Our ref: 25_34156_P

Your ref: H11-1229-25

Site Location: 59 Vicarage Lane Long Sutton
Spalding Lincolnshire PE12 9AF

Summary of Proposal:
Extensions & Alterations

TITLE
PROPOSED SITE LAYOUT

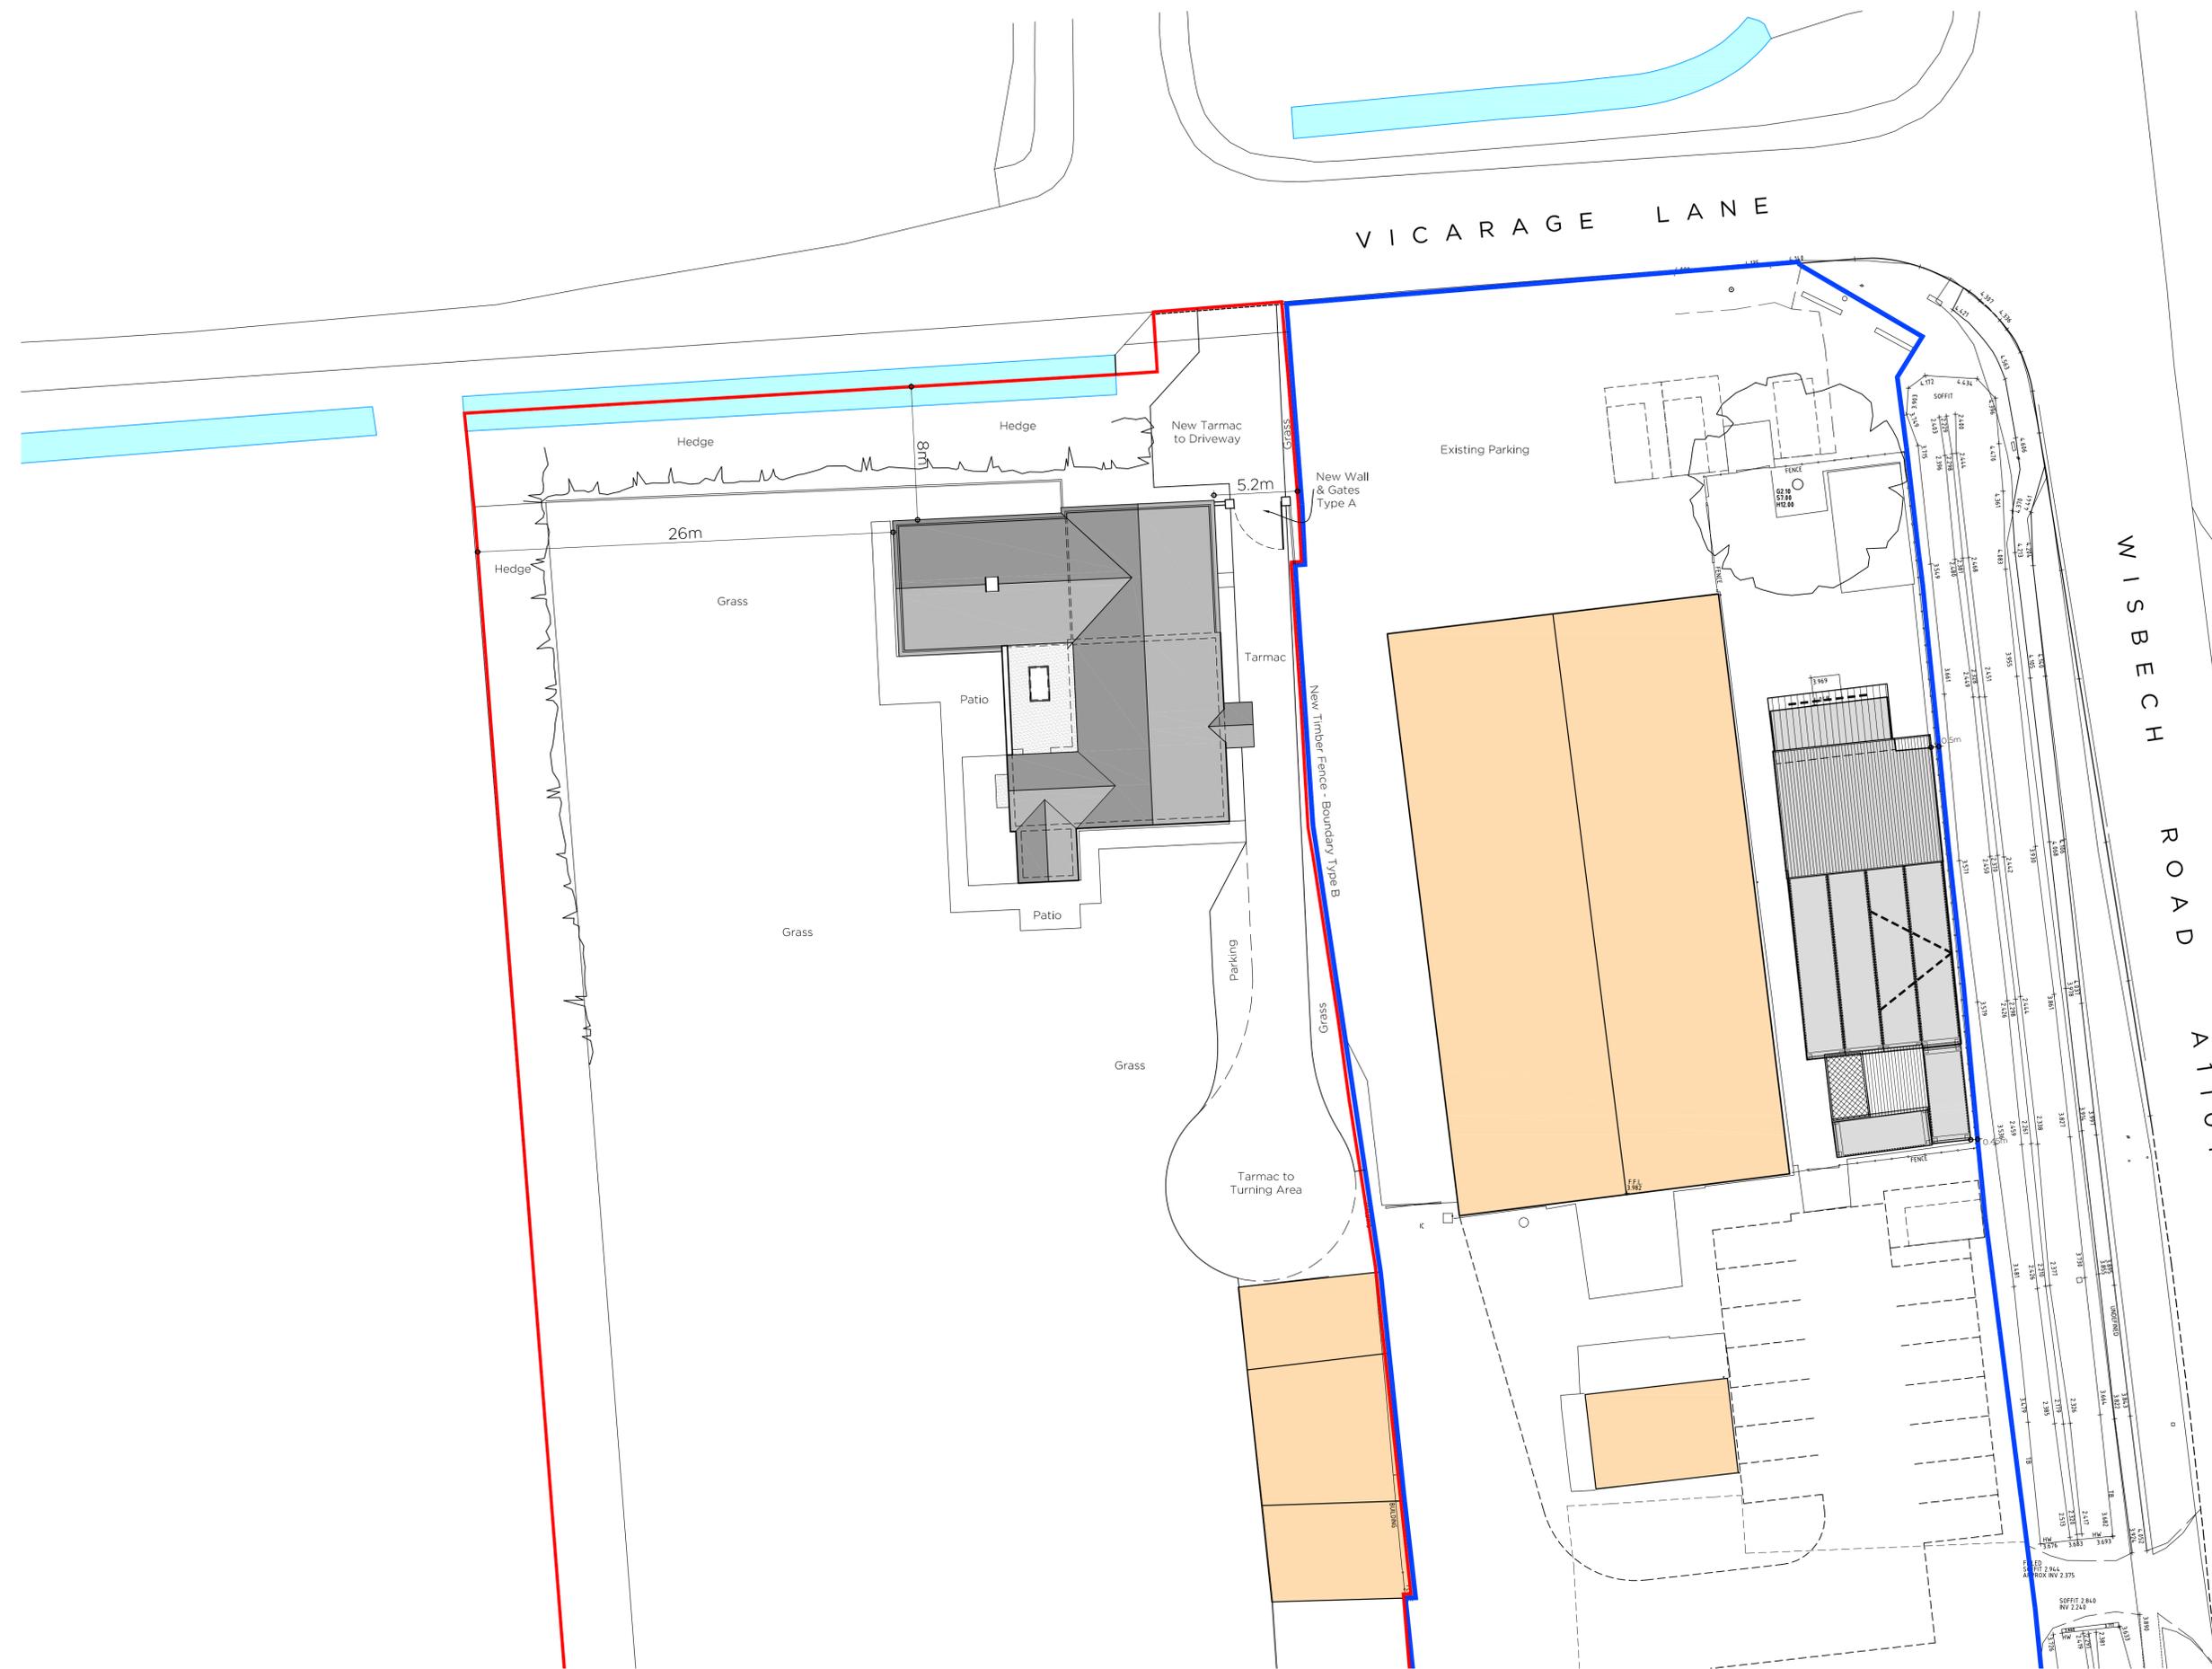
I cannot see that the applicant has identified a drainage strategy for the site within their application. We recommend a drainage strategy is provided for the site. If the applicant proposes to discharge surface water to a watercourse, consent would be required under Byelaw 3.

I note that the applicant has not indicated how they propose to dispose of foul water from the development. If the applicant proposes to discharge treated foul water to a watercourse, consent would be required under Byelaw 3. Please note that any consent granted for the discharge of treated foul water is likely to be subject to a Treated Foul Water Development Contribution fee (TFWDC) as outlined within our [Development Control Charges and Fees](#).

I note the presence of a watercourse which is not maintained by the Board (a riparian watercourse) adjacent to the northern site boundary. Whilst not currently proposed, should the applicant's proposals change to include works to alter the riparian watercourse, or if works are proposed to alter the watercourse at any time in the future, consent would be required under the Land Drainage Act 1991 (and byelaw 4).
